**Subject: Request for SEARs for Horsley Drive Business Park Stage 2 Buildings 2 and 3, corner Cowpasture Road and Trivet Street, Wetherill Park (SSD 17161650)**

## **FAIRFIELD CITY COUNCIL RESPONSE – SCOPING REPORT FOR SSD 17161650 - HORSLEY DRIVE BUSINESS PARK STAGE 2 BUILDINGS 2 AND 3**

**REQUEST FOR SEARS HORSLEY DRIVE BUSINESS PARK – STAGE 2 BUILDINGS 2 & 3 - CNR COWPASTURE ROAD AND TRIVET STREET, WETHERILL PARK**

**Horsley Drive Business Park Stage 2 – Buildings 2 & 3 – Request for SEARs (SSD 17161650)**

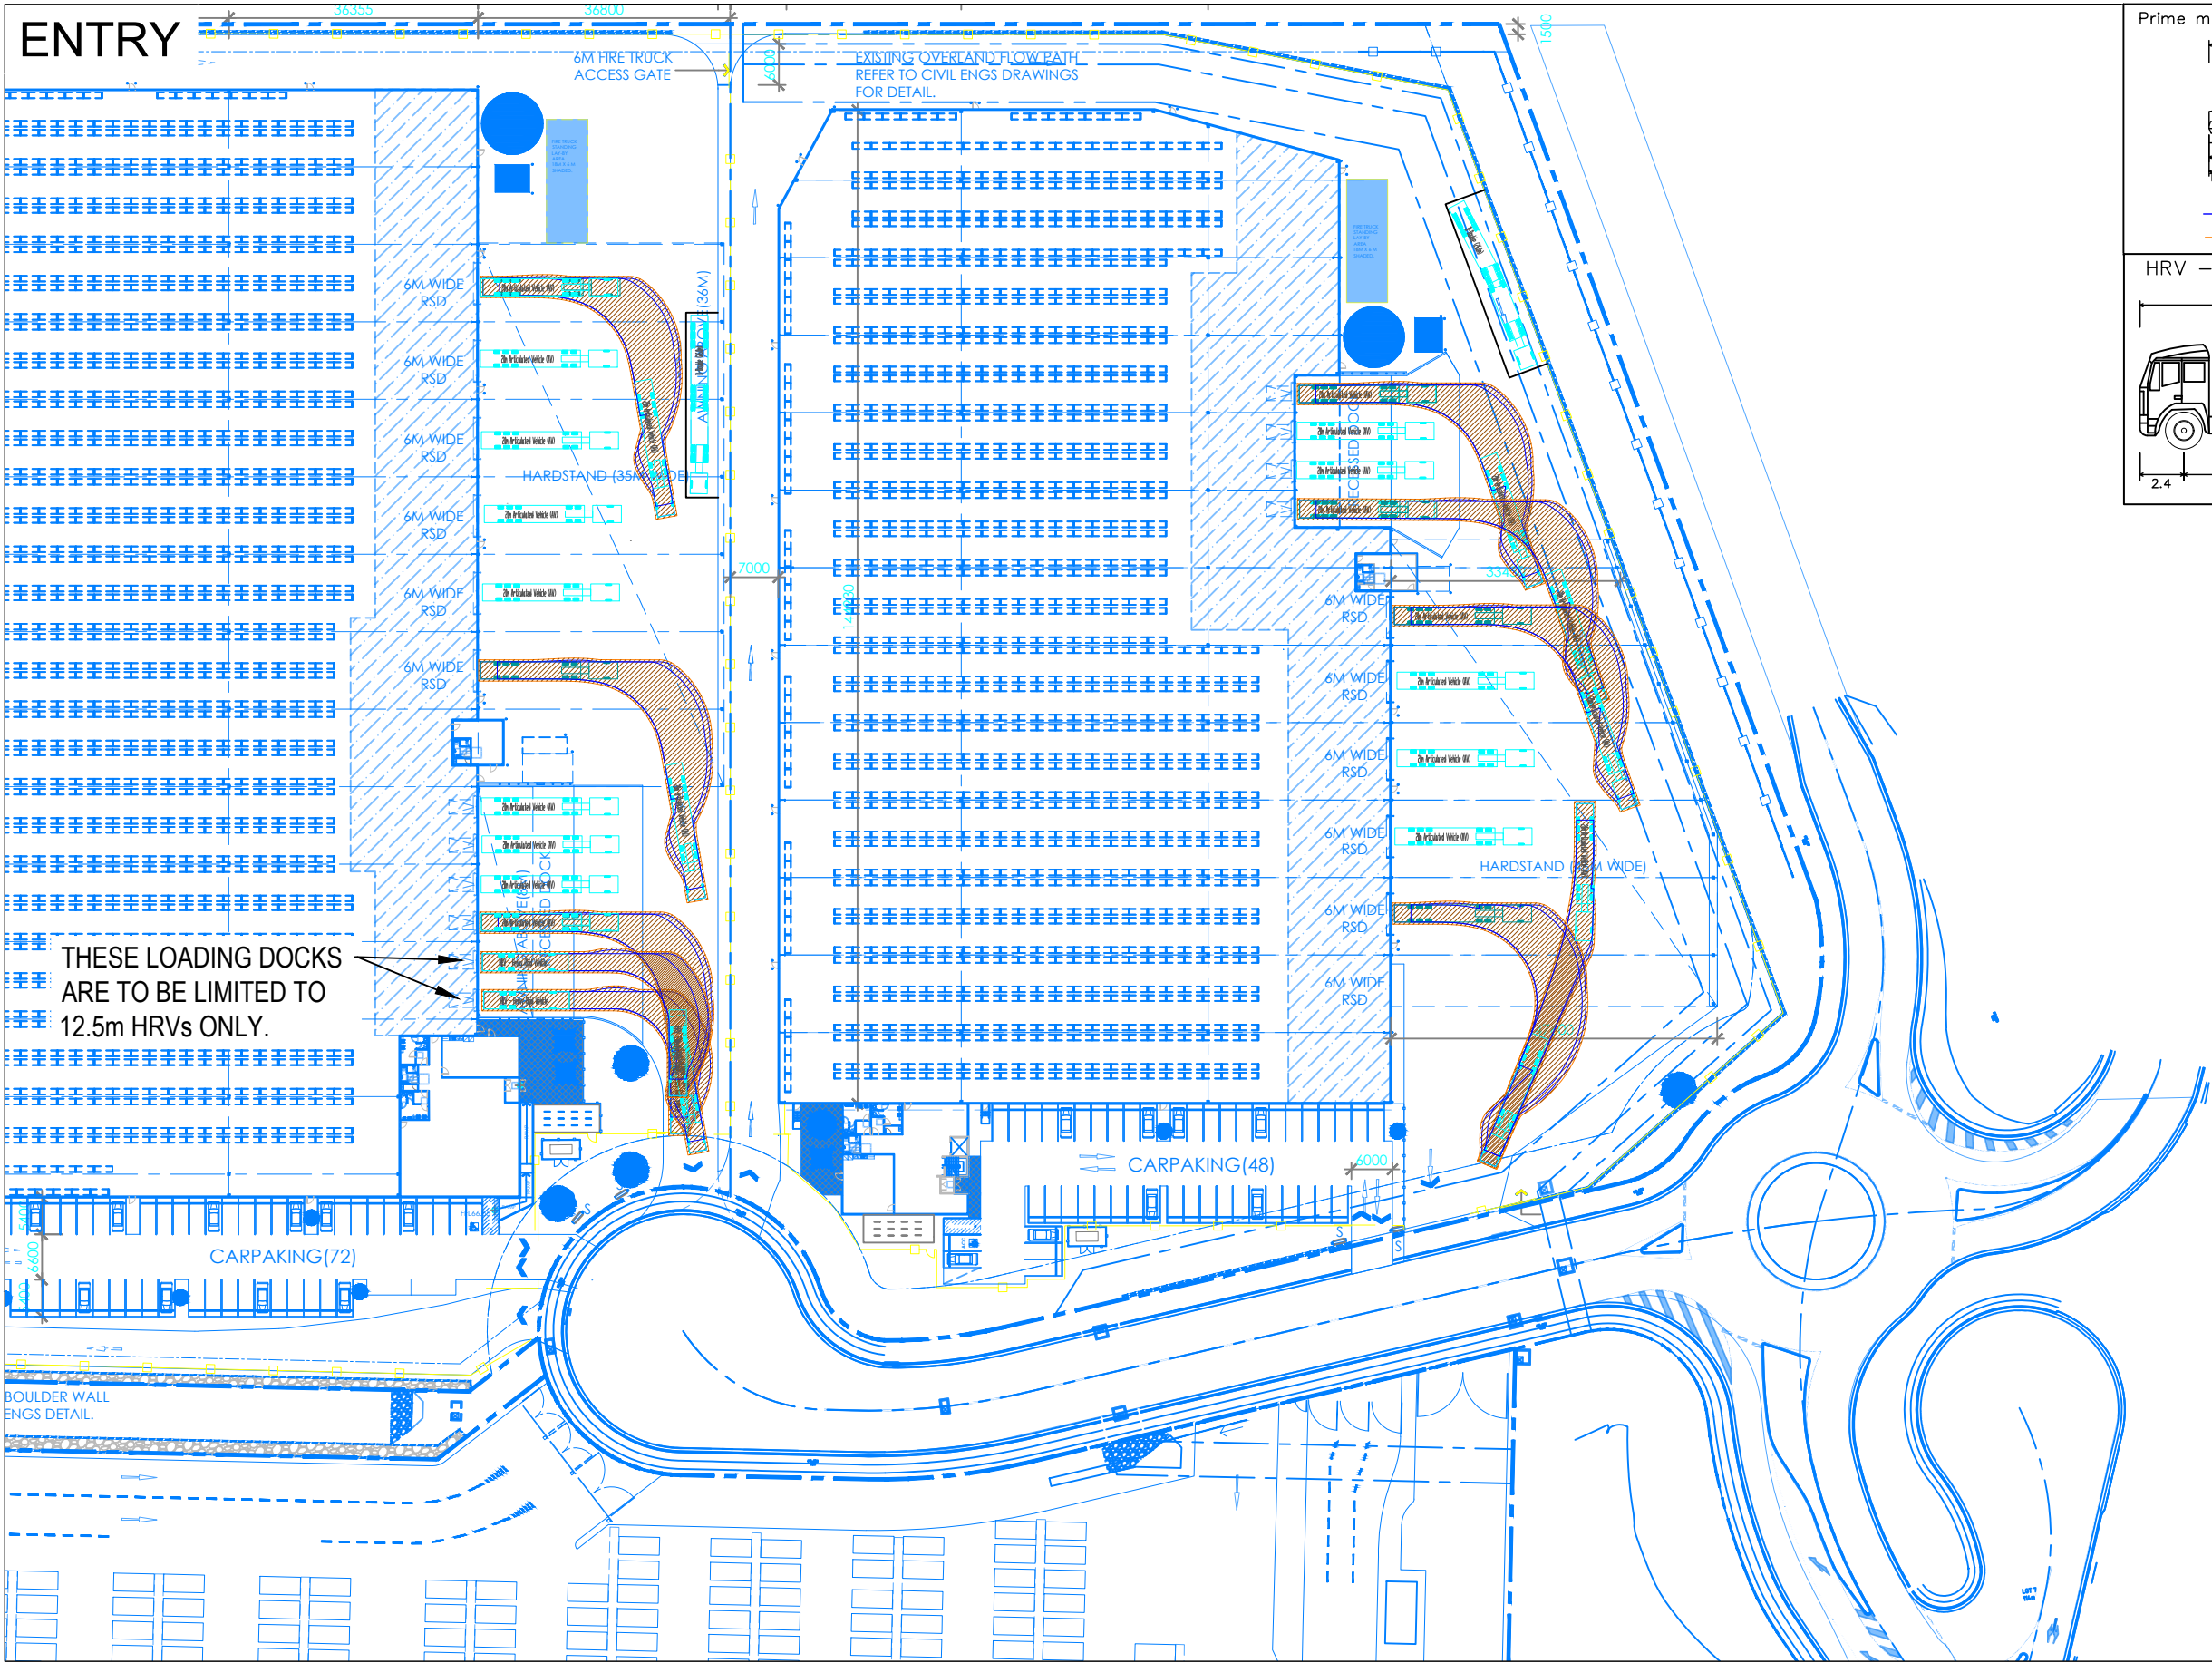
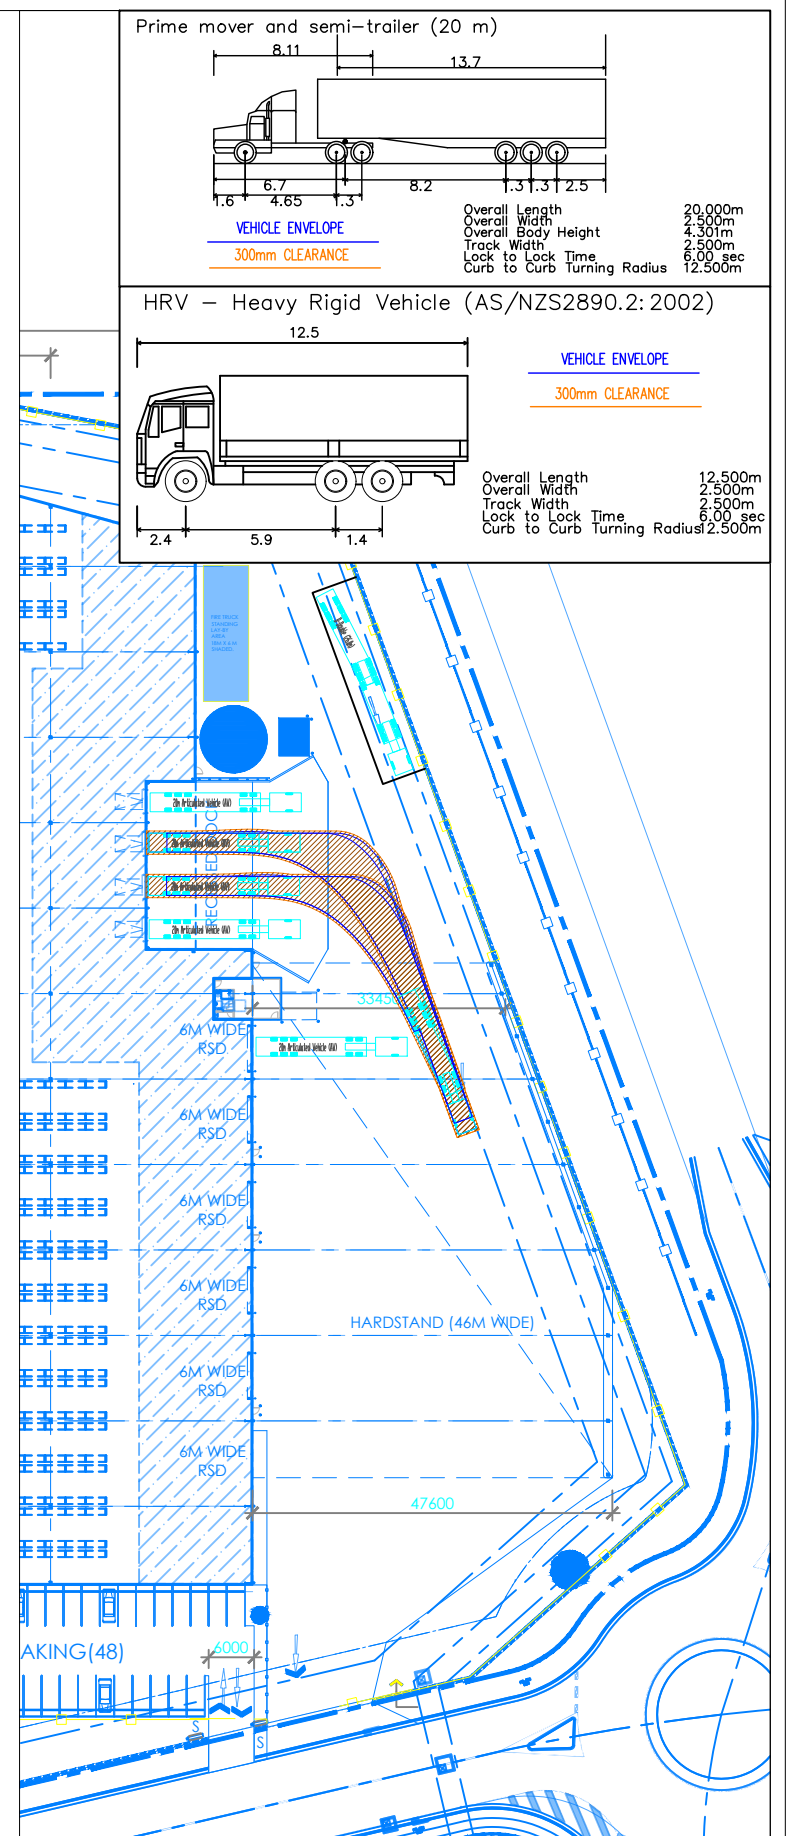
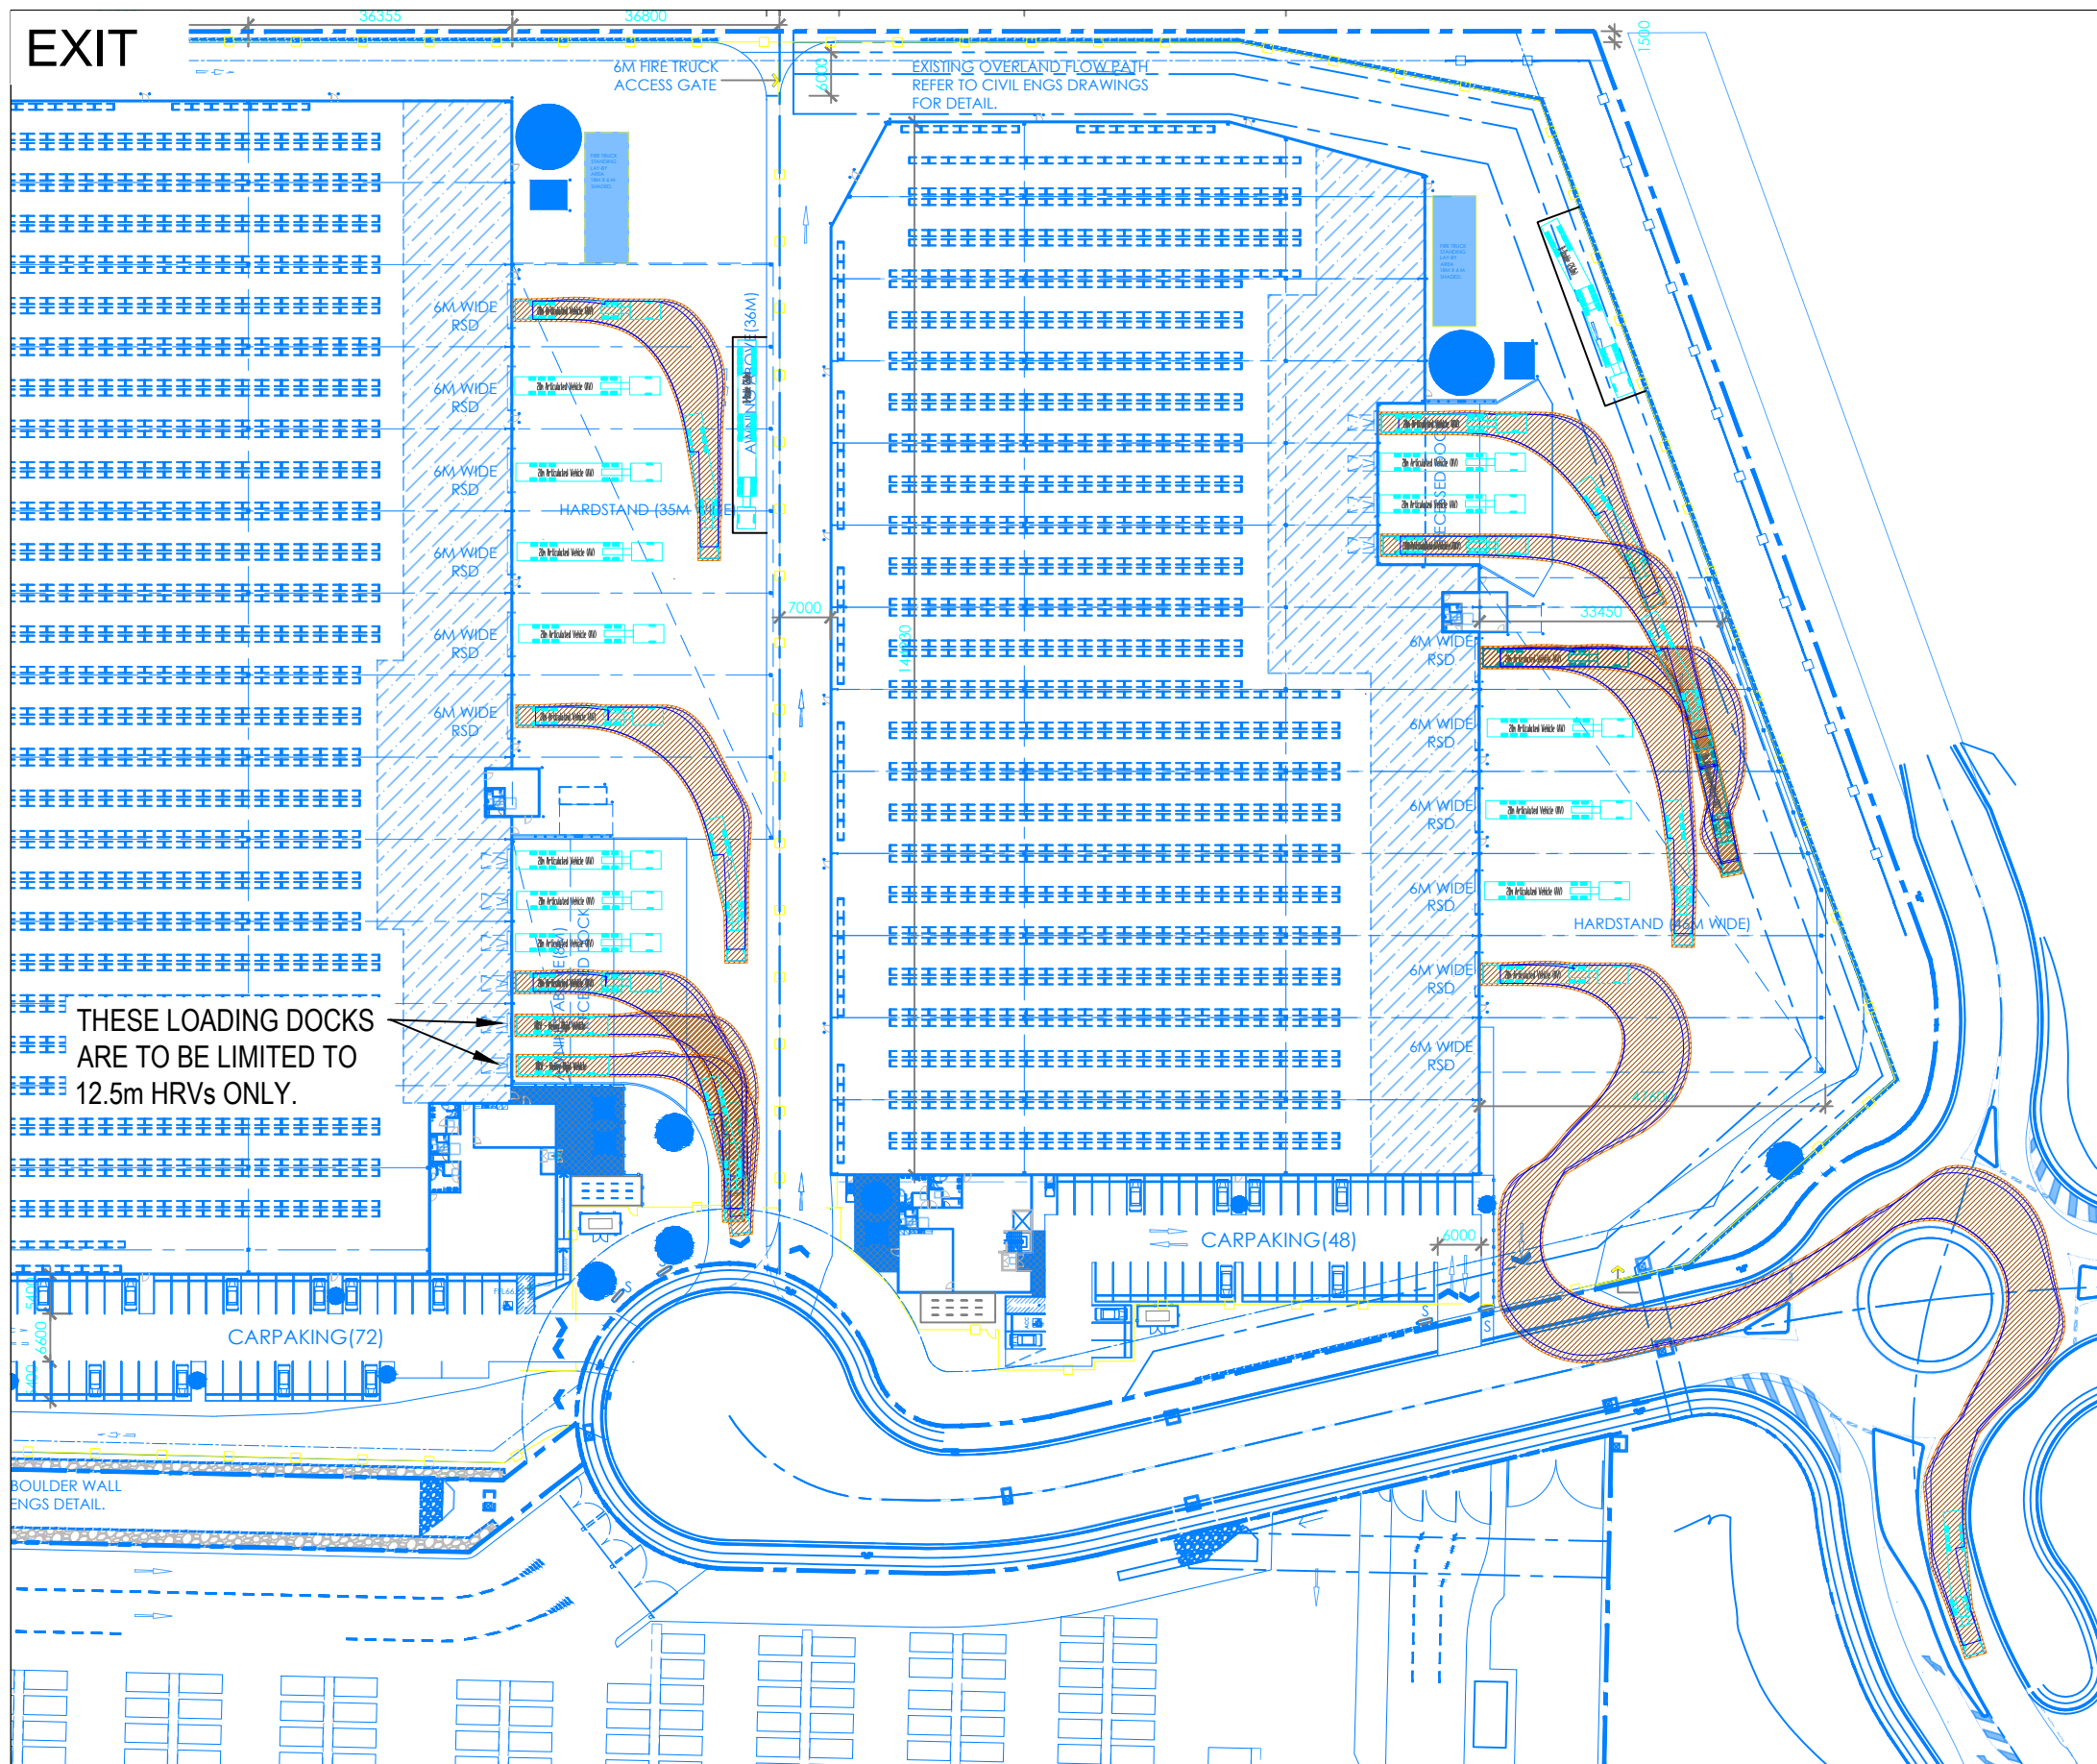
Council officers do not support the truck entry and exit points for Warehouses 1 and 2 nor the internal two-way road network for building 2 as shown on the proposed site plan (the plan).

- A. Swept Path Diagram Warehouse 2** - The swept path diagrams on the plan for proposed warehouse 2 demonstrate that HRV's are unable to pass each other at the same time without colliding whilst turning at the sites north west corner. The applicant must demonstrate that HRV vehicles can pass without collision at the north-western portion of the internal road at proposed warehouse 2.

- B. Estate Road Movements** - HRV vehicles egressing from proposed warehouse 1 cannot make a safe turning path onto the estate road without conflicting with the HRV vehicles entering and or exiting from warehouse 2. The plan shows HRV's turning left from Cowpastures Road travel on the wrong side of the estate road for a considerable distance before ingress into the warehouses. This poses an unacceptable risk to estate road users especially for the 119 smaller vehicles that would make use of the car parking onsite. Additional information must be provided to Council to address these concerns.
